An
Coimisiún
Pleanála

Inspector's Report

ABP-322734-25

Development	Demolition of three agricultural sheds, construction of 362 residential units, and associated site works including upgrades to Mountain Road. An EIAR was submitted with the application. (www.mountainroadlrd.ie)
Location	Mountain Road, Kilmoney, Carrigaline, Co Cork
Planning Authority	Cork County Council (CCC)
Planning Authority Reg. Ref.	25/4551
Applicant	Bridgewater Homes Ltd.
Type of Application	Large-Scale Residential Development (LRD)
Planning Authority Decision	Grant Permission
Type of Appeal	<ol style="list-style-type: none">1. First Party v Condition2. Third Parties v Grant of Permission
Appellants	<ol style="list-style-type: none">1. Bridgewater Homes Ltd. (Applicant, First Party)

Fig 3: Autotrack of Mountain Road Upgrade showing two large vehicles comfortably passing.

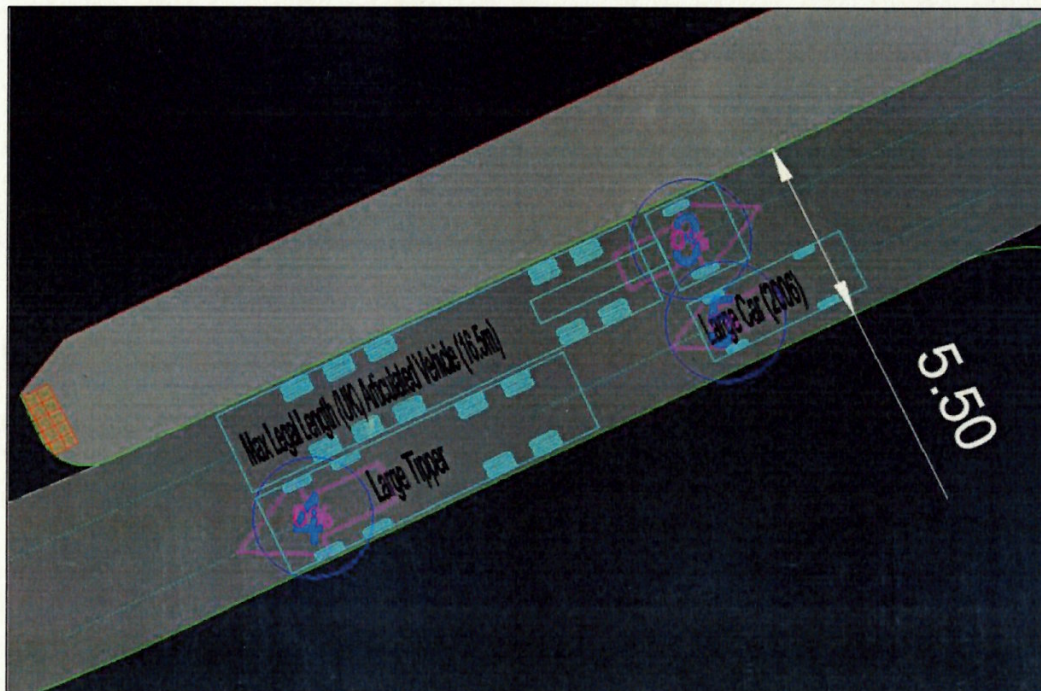
- The proposed upgraded road will be substandard in width. 5.5 metres is not adequate and 6 metres would be required.
- The construction methodology lacks detail.

## X sections

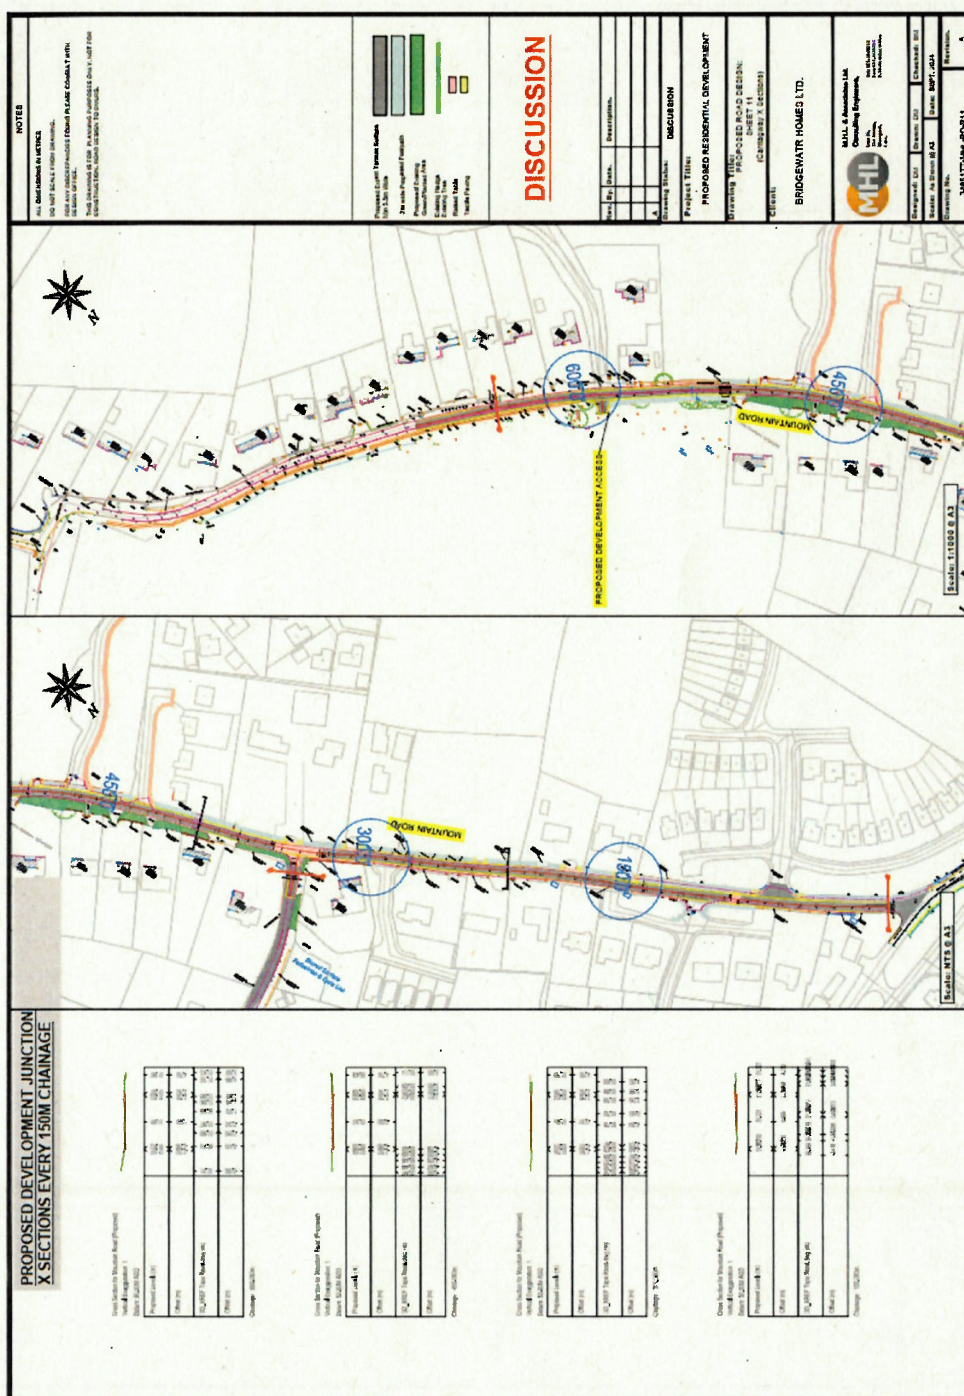
- No proposed cross section drawings of Mountain Road are provided. Two have been prepared using application information and are included in the appeal. The red line boundary width is not adequate to accommodate a temporary road given existing and proposed services. There is no confirmation that more land is available than shown on the consent drawing and one affected landowner (also one of the eight appellants) made a submission to CCC that permission for extra land has not been sought and will not be given. 'Traffic management' is insufficient to mitigate the impact of construction on residents.

- The CTPREP clearly indicates that vehicular access to the subject site is from Mountain Road with pedestrian and cycle connectivity from the east.
- The increase in width of Mountain Road to 5.5 metres is in accordance with DMURS for roads of this type (local road). Autotrack shows this width can accommodate large vehicles without them mounting kerbs. A DMURS technical note is attached as appendix 1 demonstrating that Mountain Road is fully DMURS compliant.
